Response to Planning Application

From: Arun District Council Greenspace

Application ref: Y/127/21/RES

Location: Land at Bilsham Road Yapton

drawing title
Open Space Provision

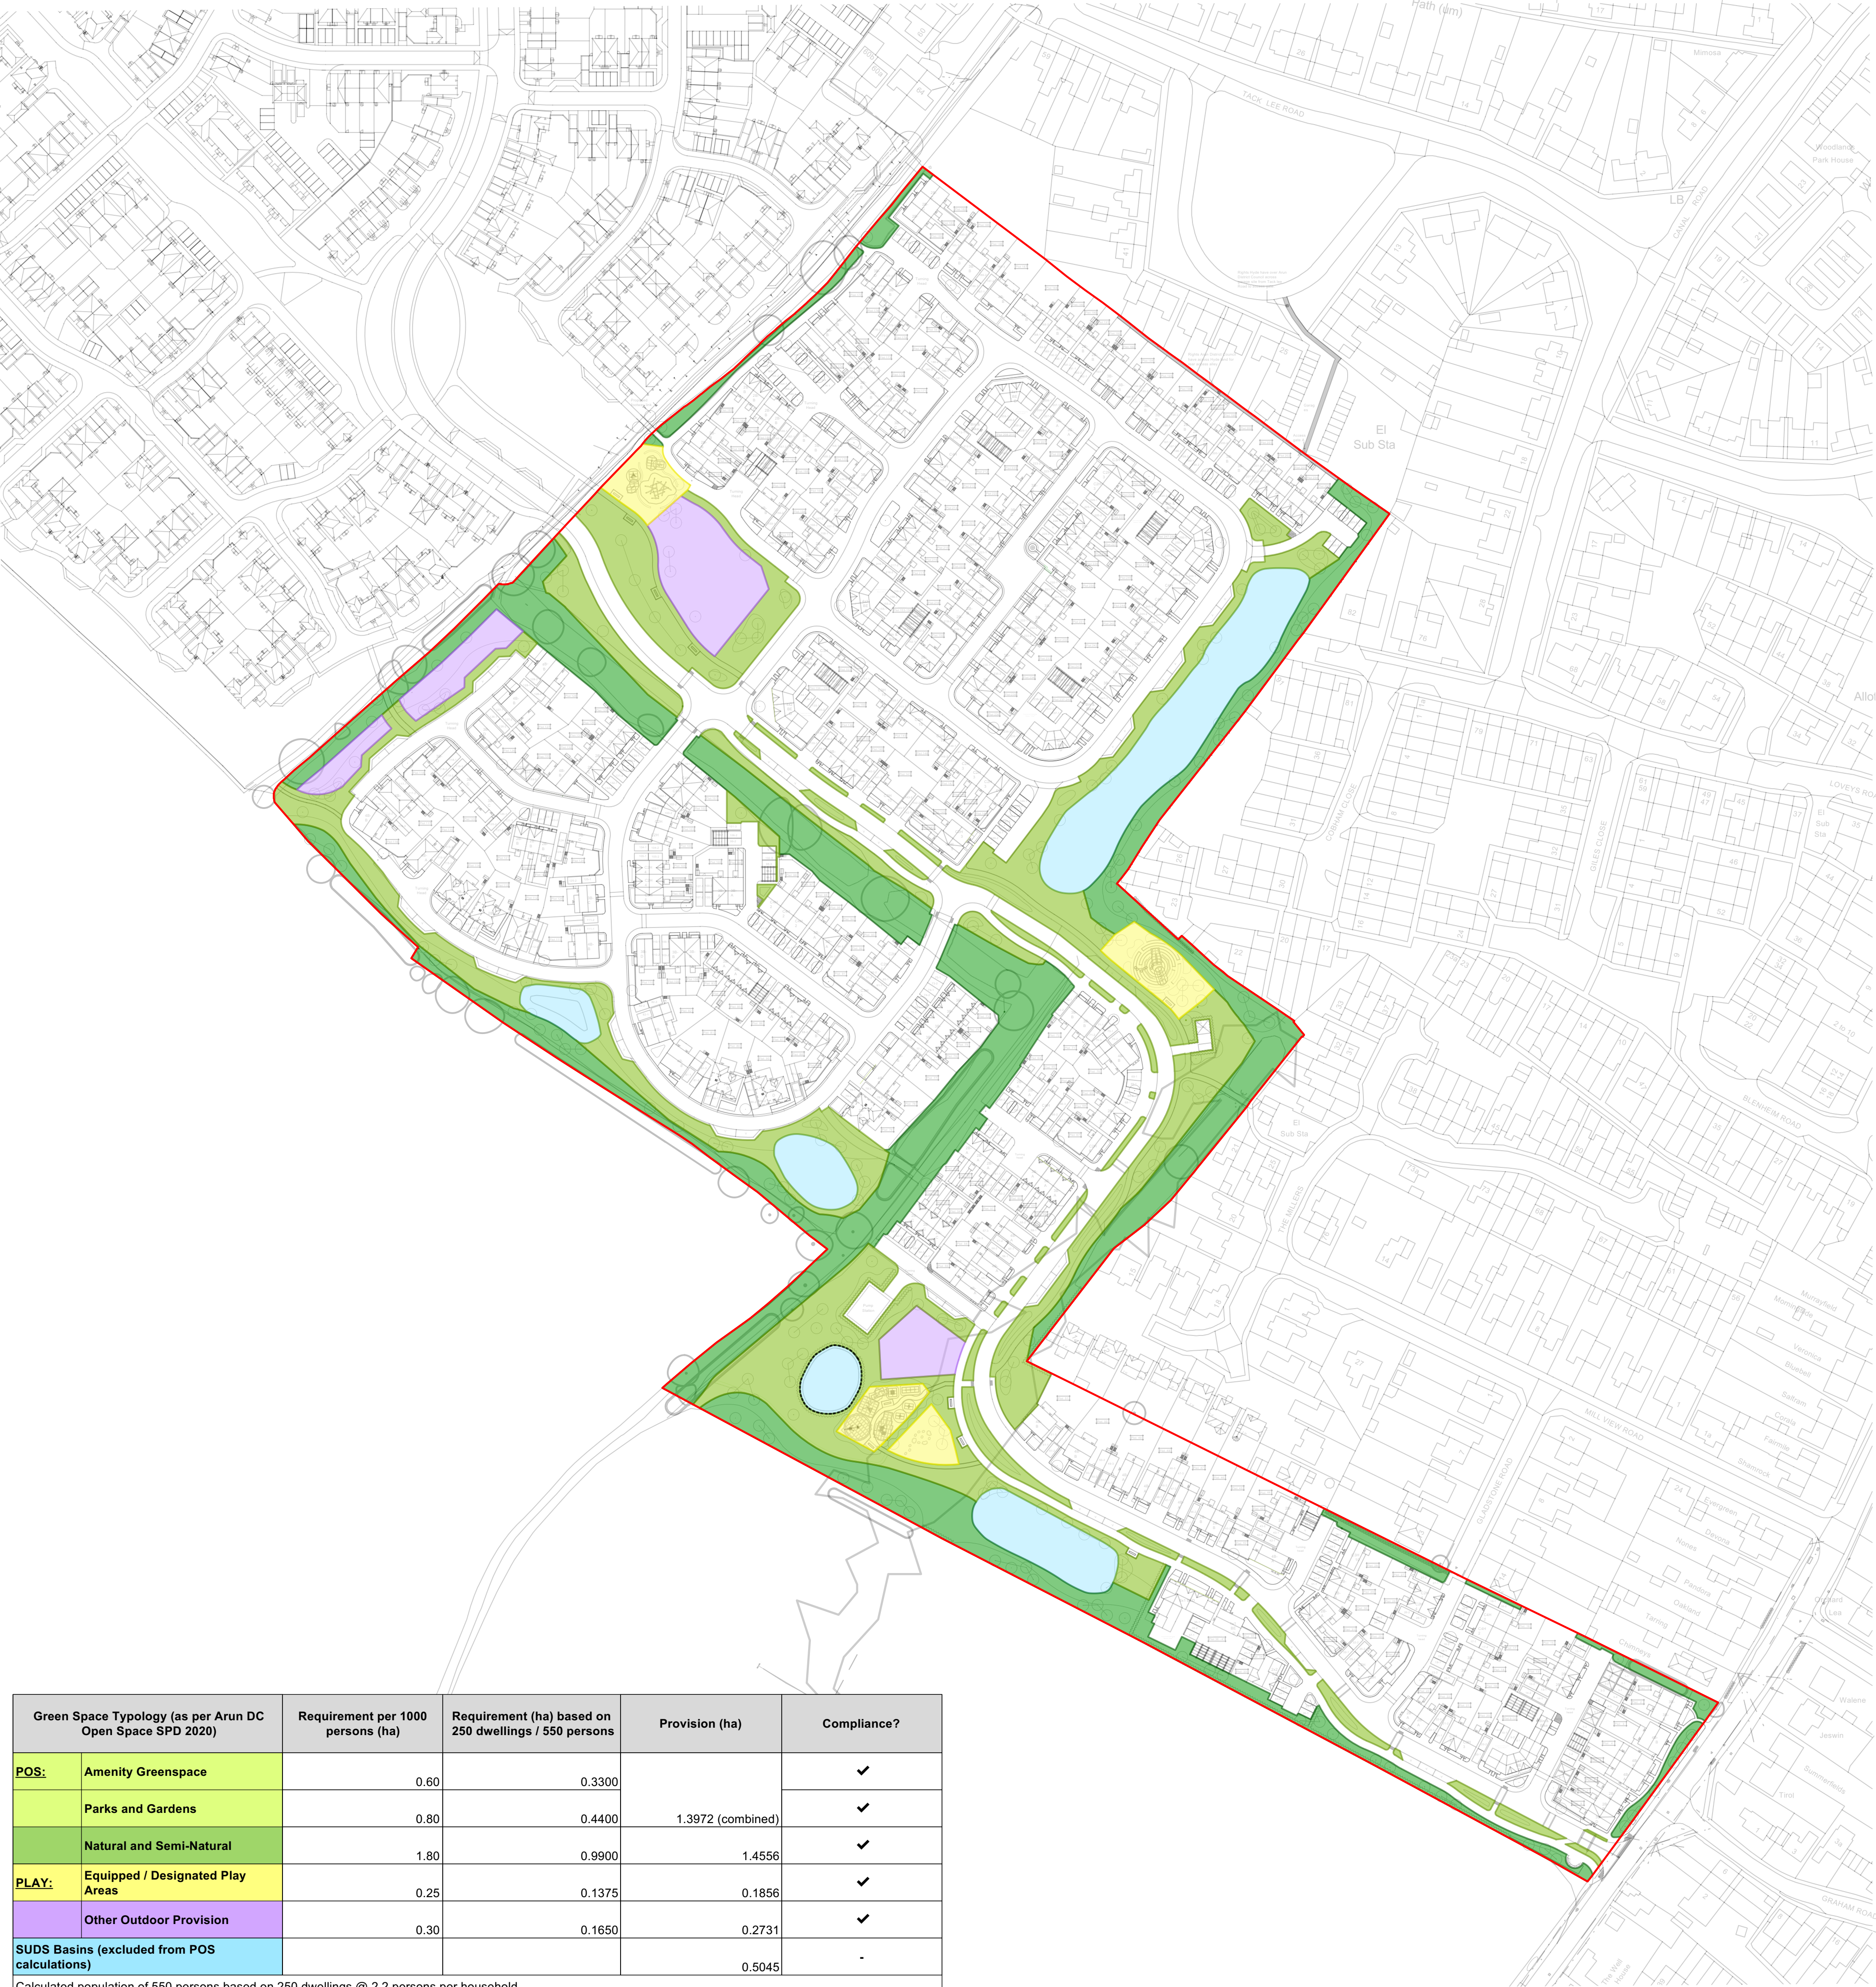
- The SuDS features within the POS areas have been quantified and confirmation provided that excluding these features the quantum of usable POS still conforms to our Open Space, Playing Pitches, Indoor and Built Sports Facilities SPD, Jan 2020.
- The path and cycleways for formal routes including play area and POS pathways have now been shown as Tarmac finish as requested. Yapton Parish Council have previously asked for path and cycleways throughout the site and across the POS areas to be DDA compliant and of Tarmac finish in order to allow year round high trafficked access. Accessibility within and beyond the proposals and to PROWs should be promoted and recommended that all routes within the application site should be dual use (pedestrian and cyclists) with confirmation of width and surfacing in accordance with WSCC criteria.

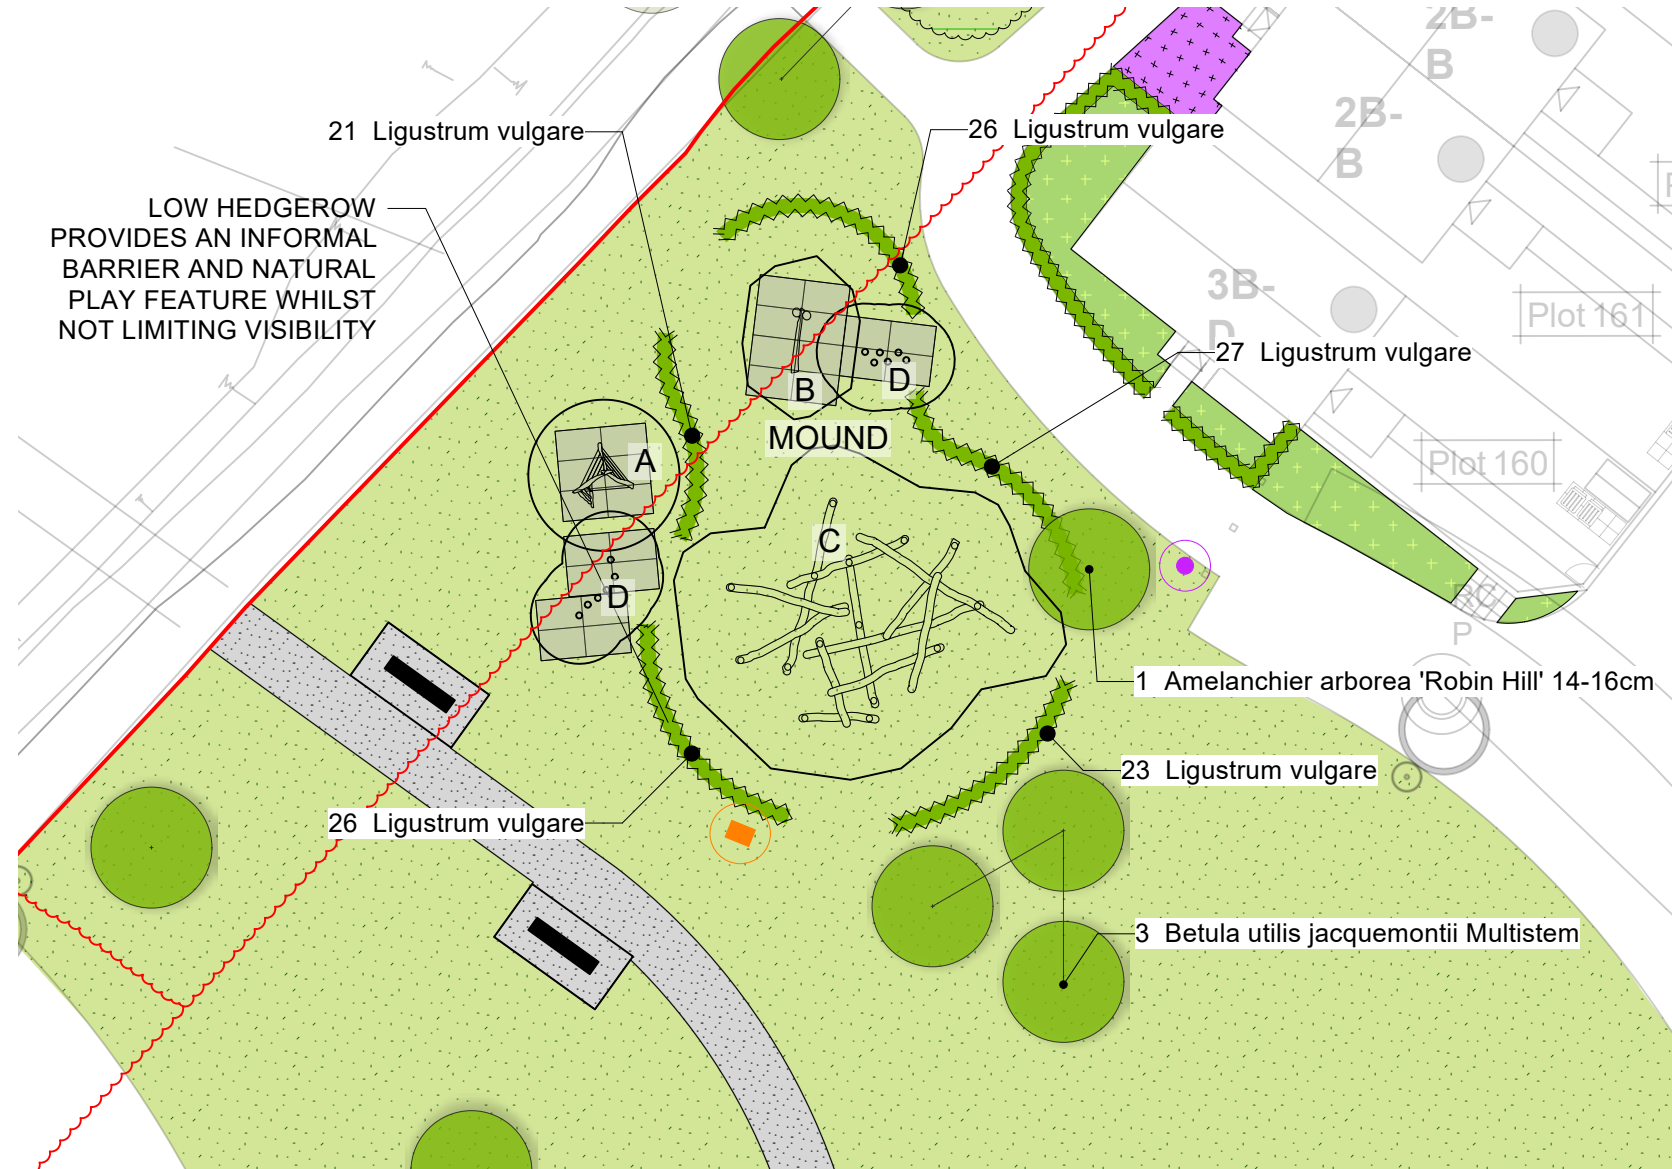
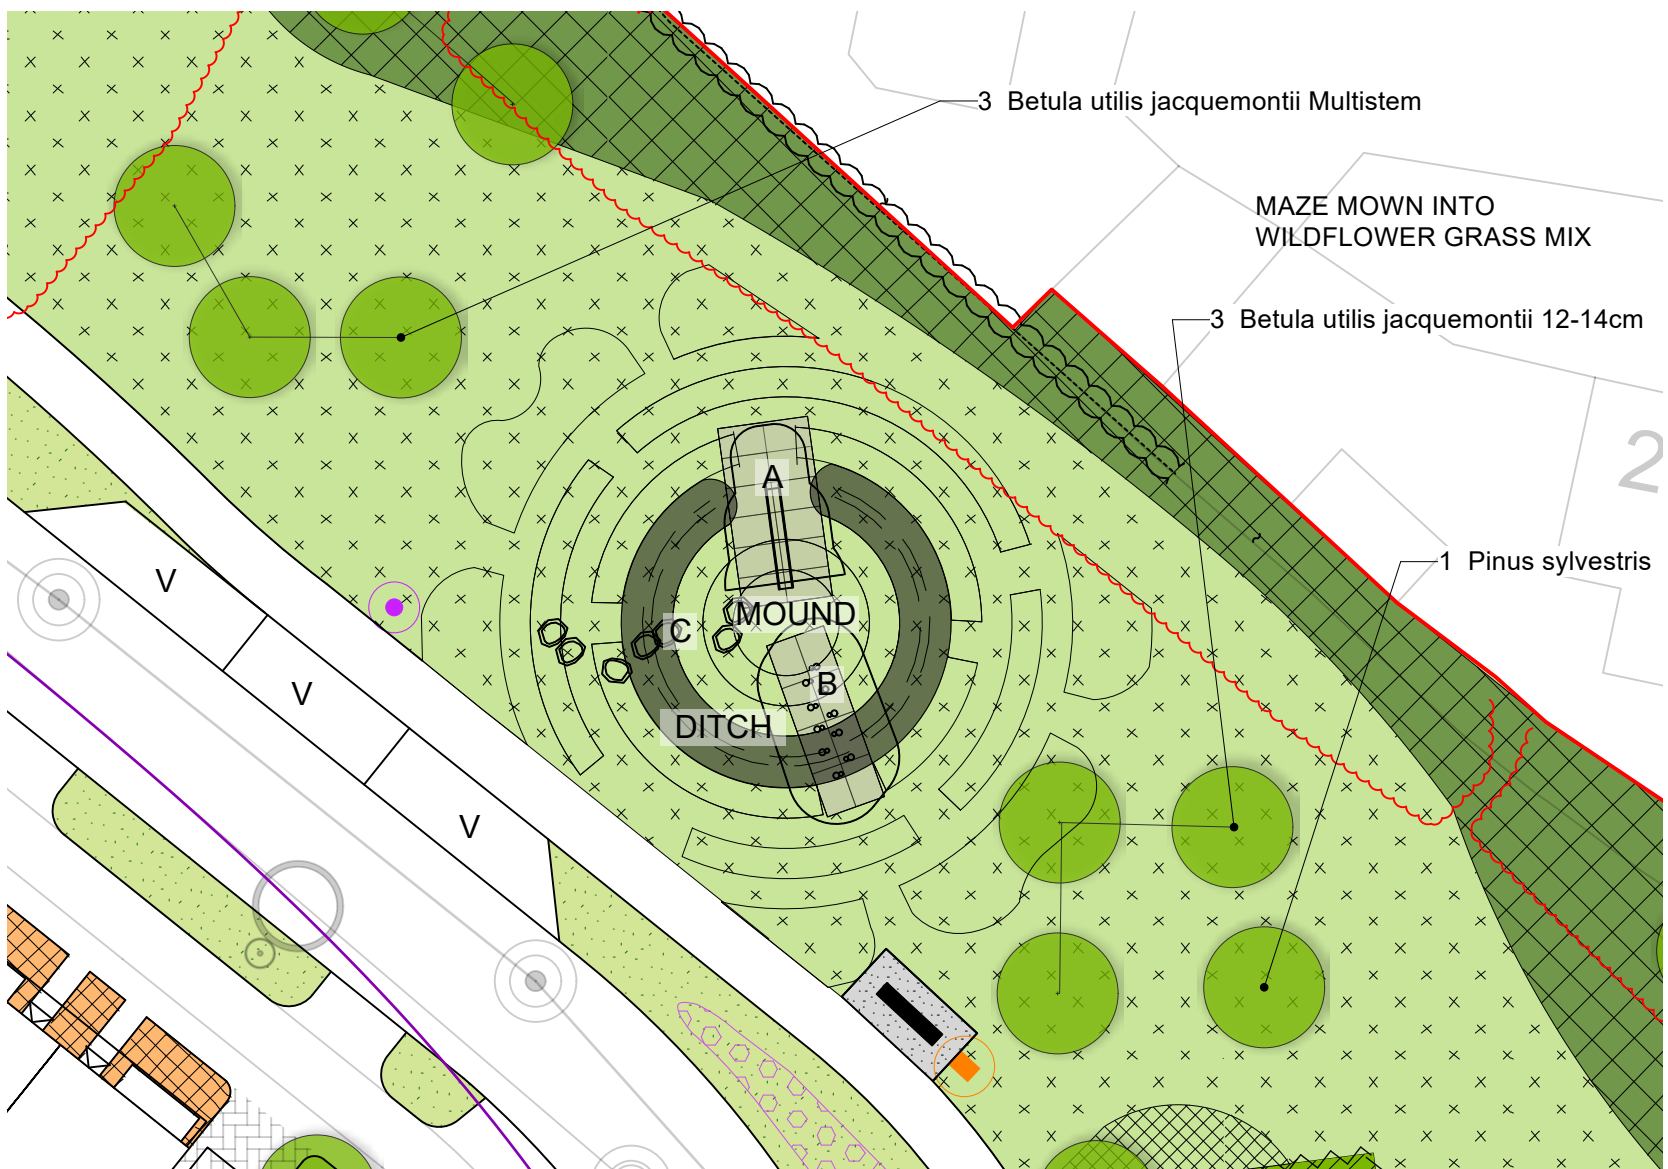
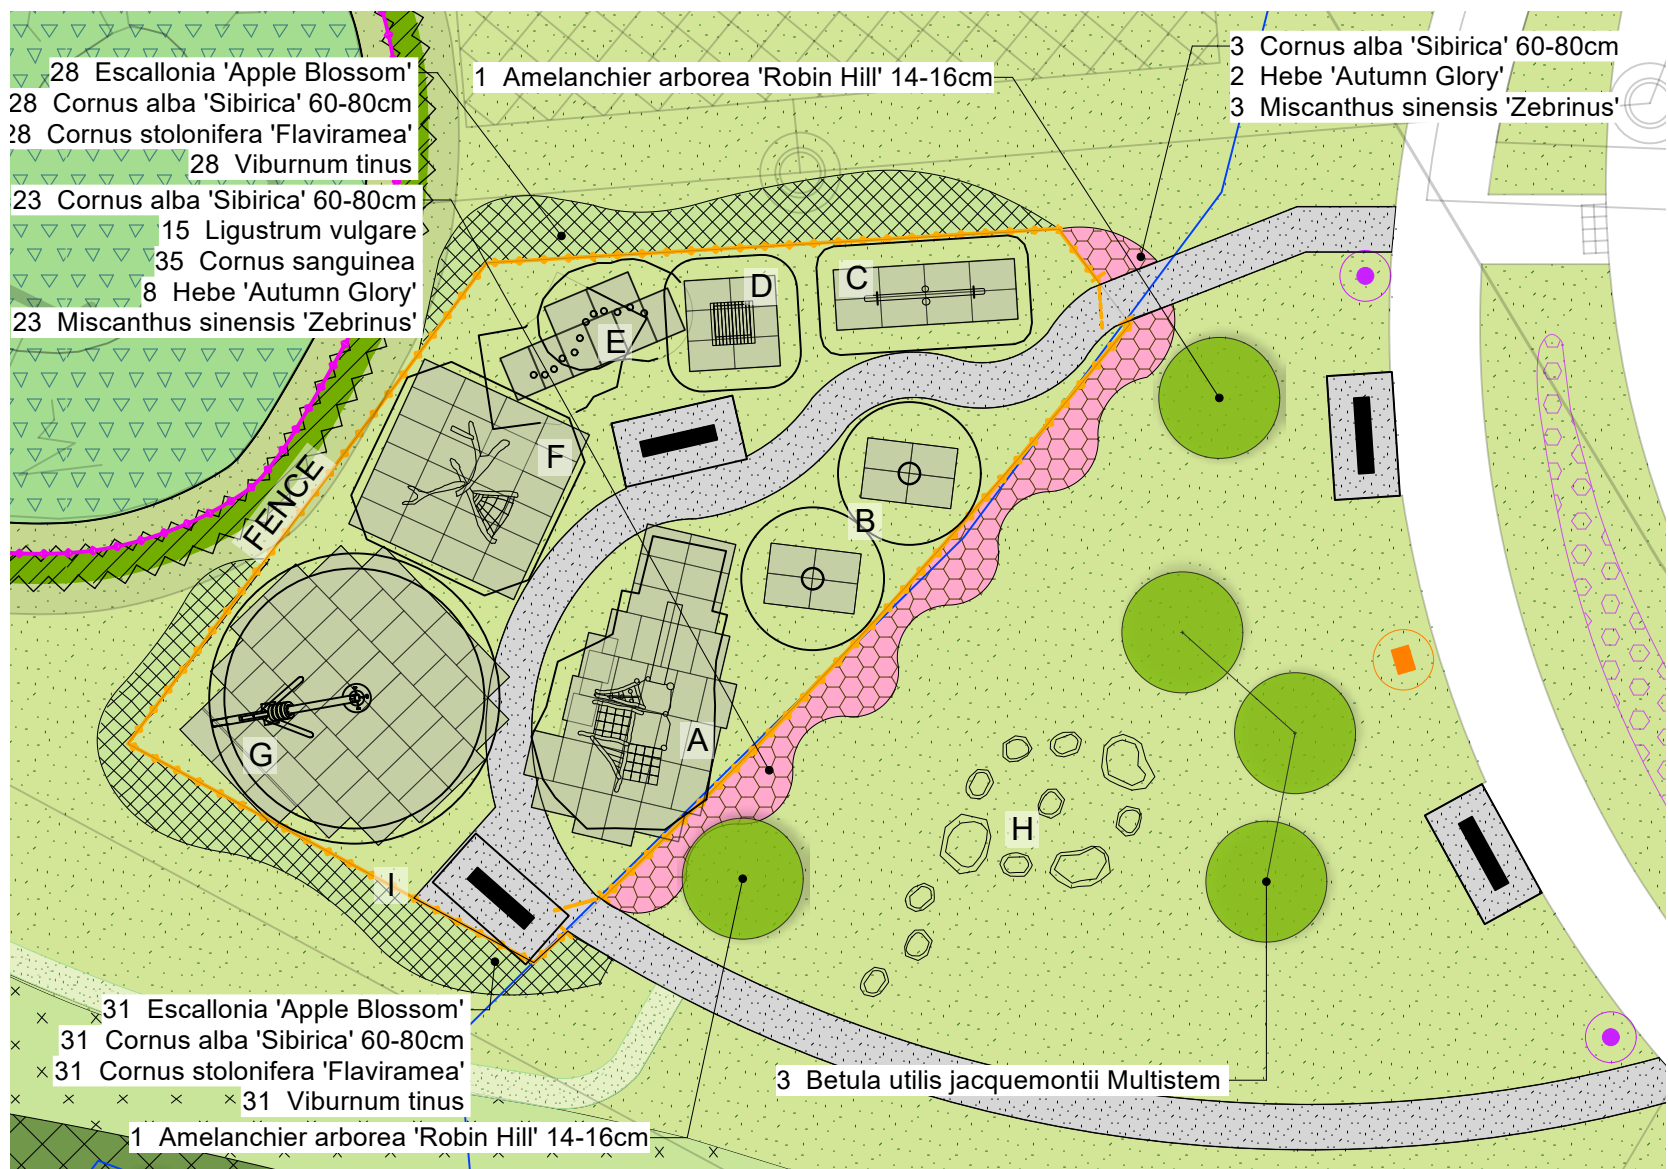
The Landscape proposals Play Spaces dwg Sheet 11 111B has provided detail of 2no LAP and 1no LEAP area. These details have proposed a scheme which will provide a variety of formal and informal play with a good mix of play experience. These areas have included suitable connectivity and pathway access with appropriate safety surfacing.
